Application No: P/53/22/DOC
Site Address: Land at Spinnaker View Pagham
Description of works: Approval of details reserved by condition imposed under P/165/21/PL relating to condition 3-Arboricultural Method Statement and tree protection plan.

Thank you for your internet representation made on 4th May 2022 which has been recorded as an objection with the comments as follows:

**Spinnaker View**  
**Appendix 2 - new site layout plan**

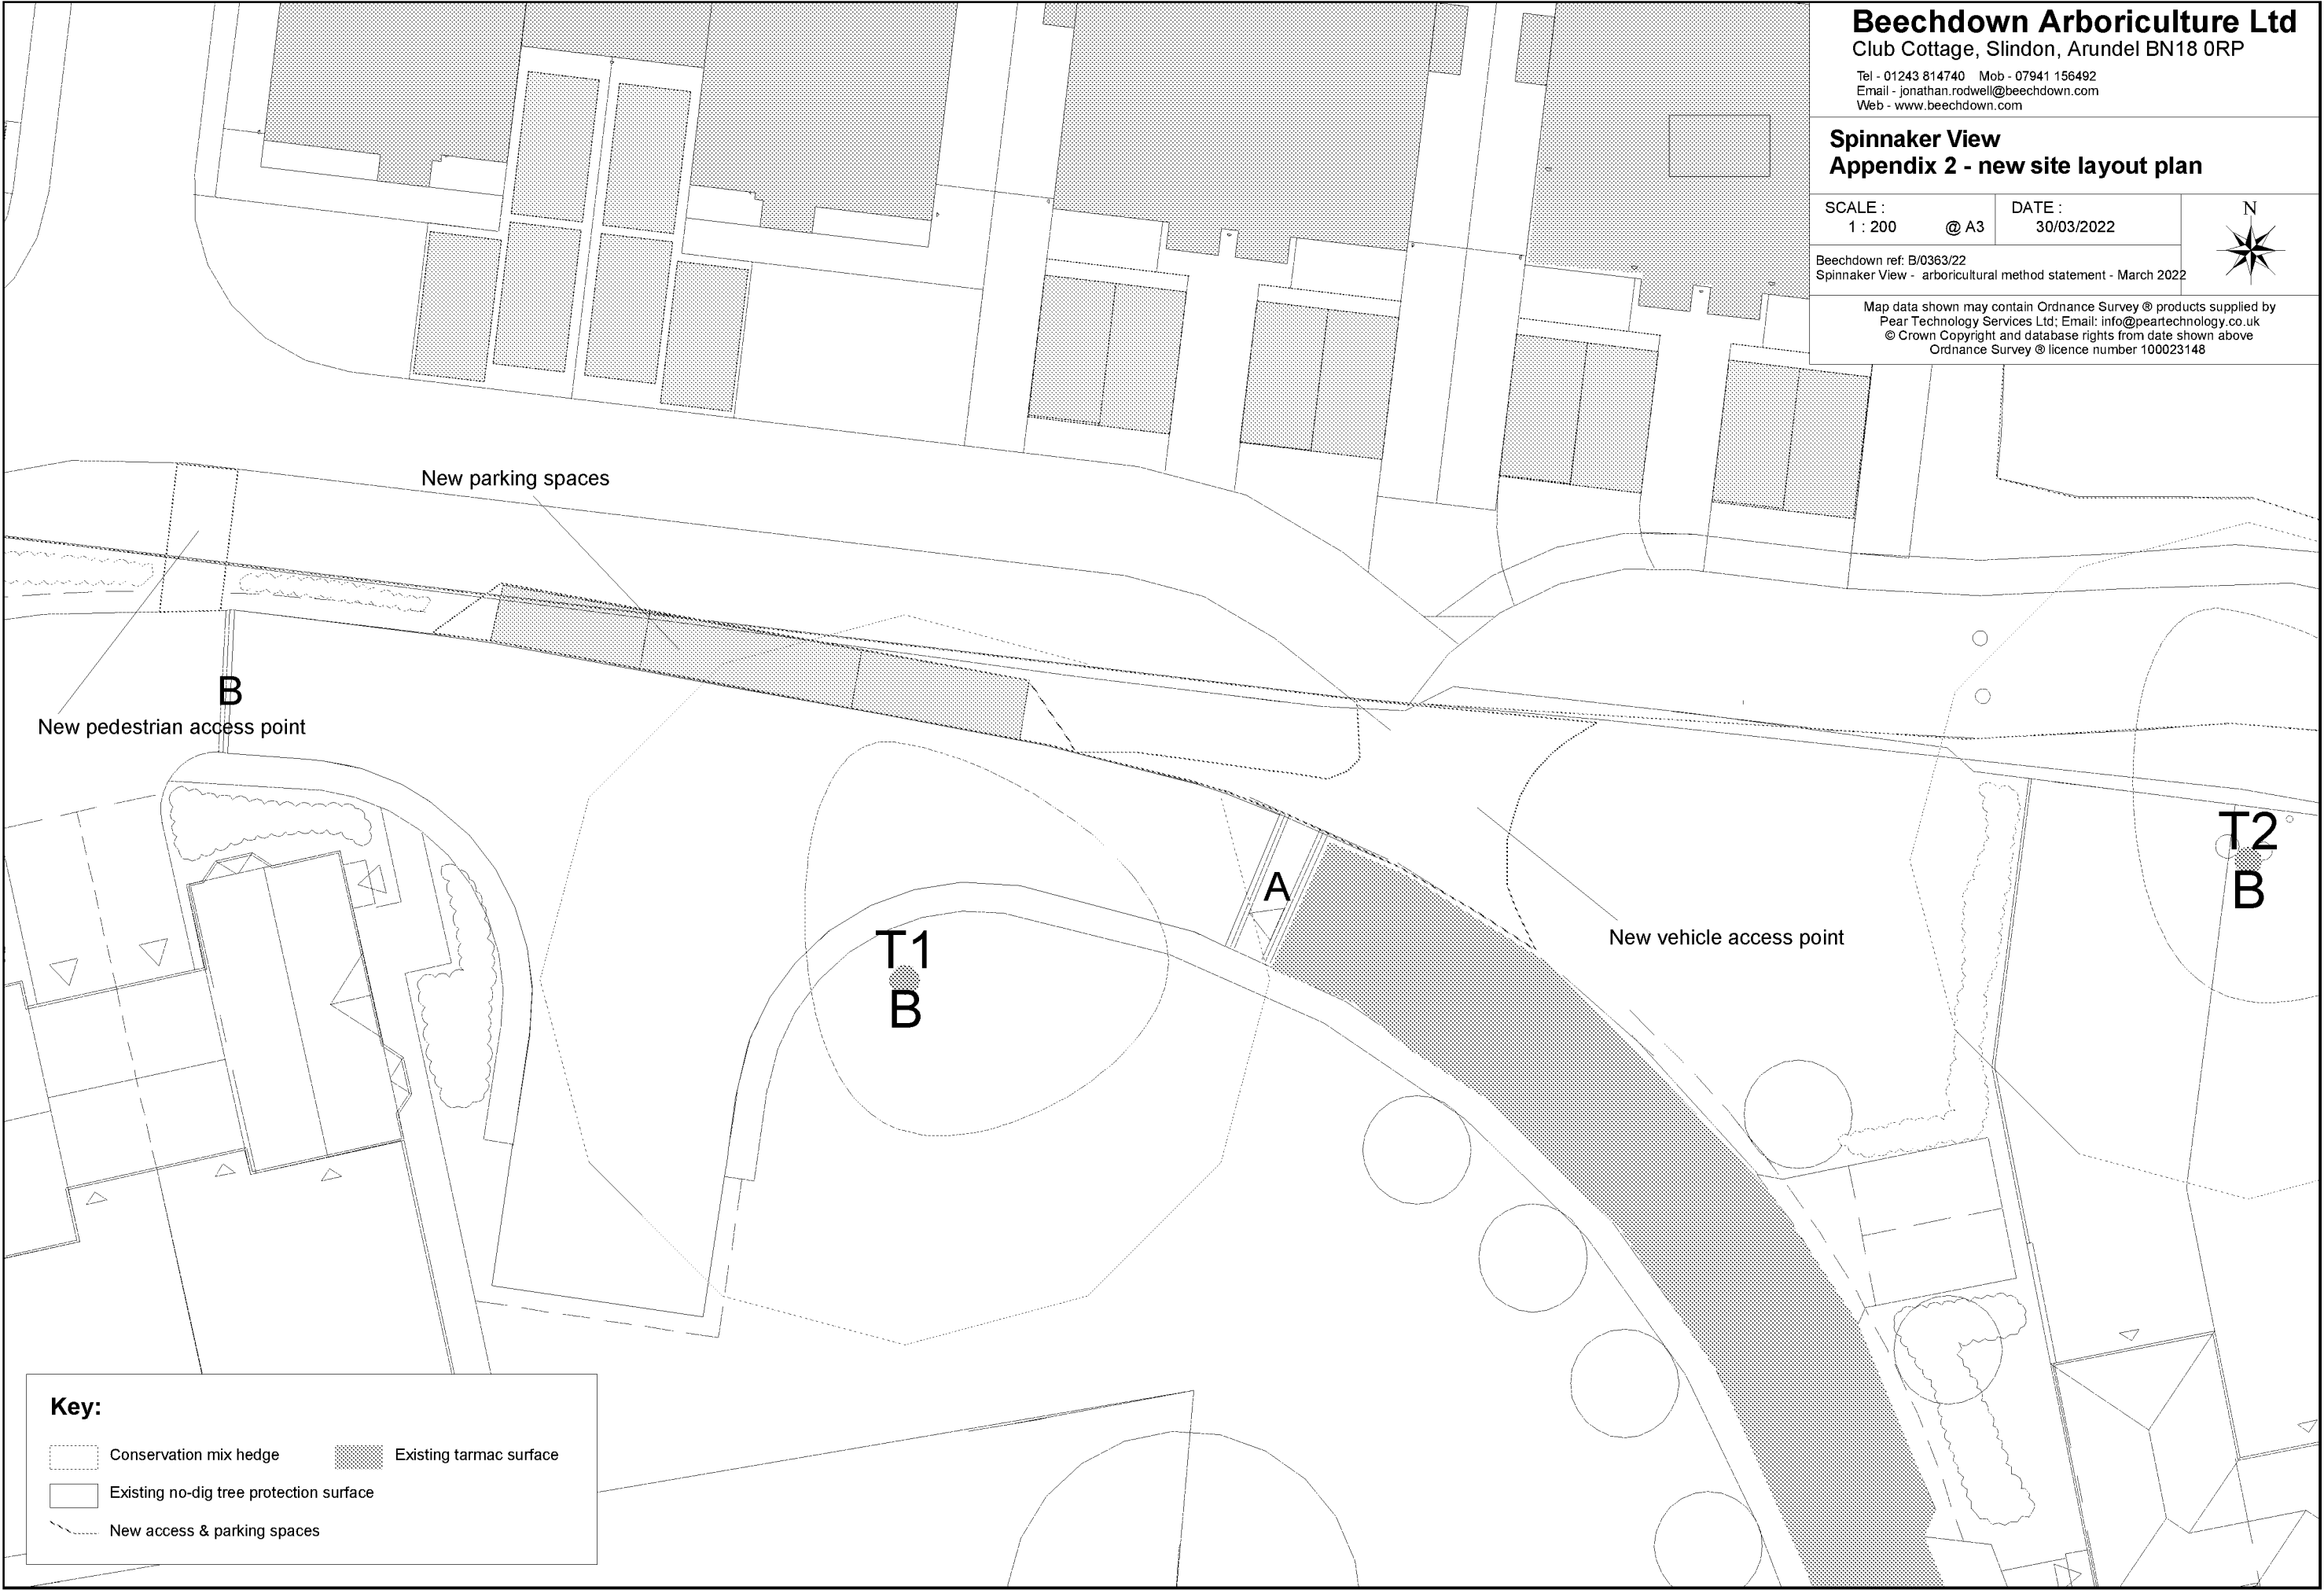
Regardless of what permissions may or may not be in place in respect of access, we must reiterate once again that you do not have the right or authority to remove our parking spaces and relocate them nor remove our footpath or any other means of reconfiguration or damage of our site layout which is private land owned solely the residents.

We also do not give permission for the removal of our 2 willow trees and a rowan tree and our conservation mix hedging on the boundary between Spinnaker view and the land to the rear of the inglenook hotel, these trees and hedges are now three and a half years old and established giving character to our site.

**Spinnaker View**  
**Appendix 3 - tree protection plan**

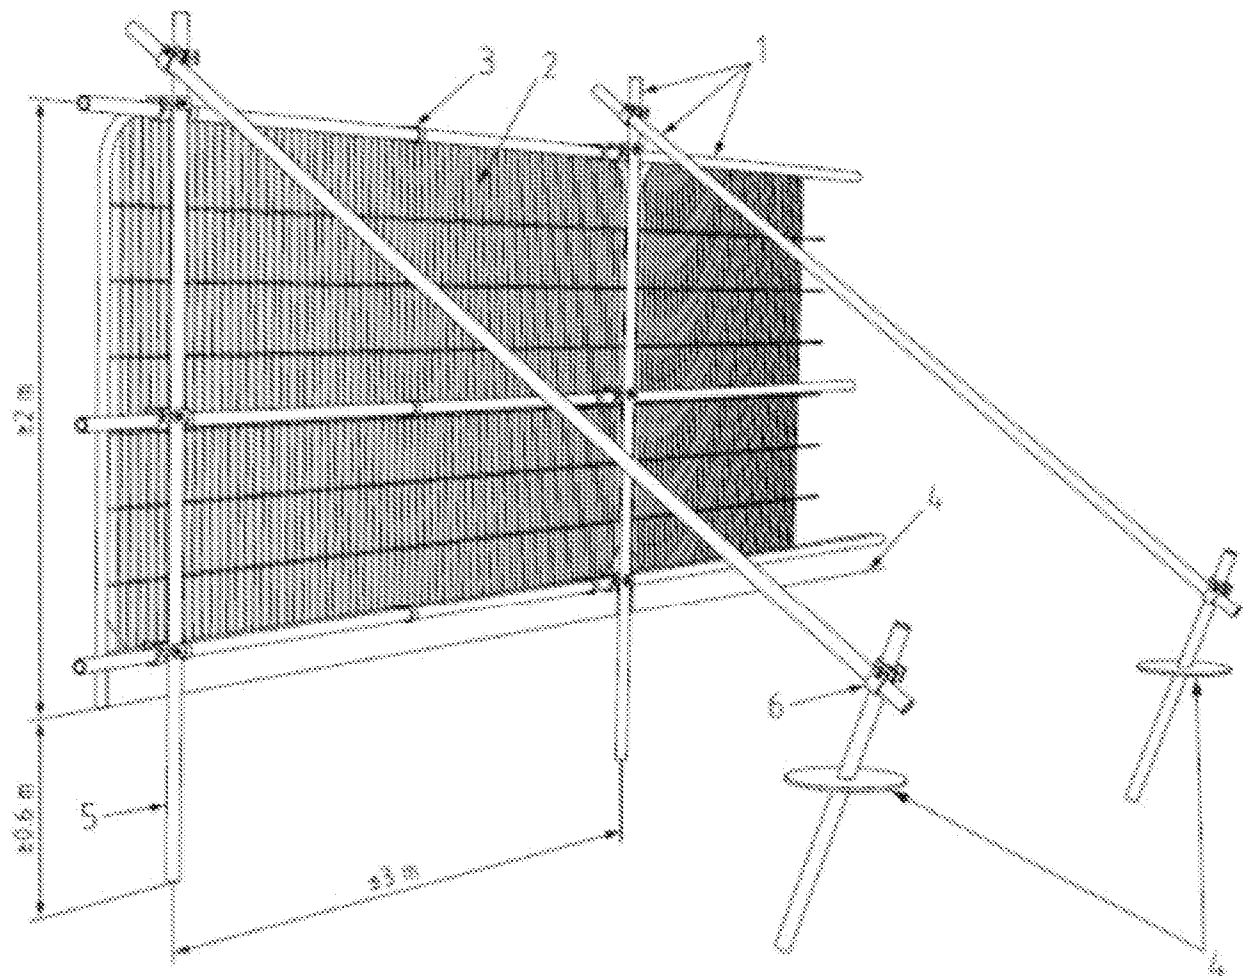
The use of protective fencing is prohibited as this will shut off our road and will cause damage to our permeable paving. Have the council / developer actually thought where residents are going to park (during construction) as all spaces are used.
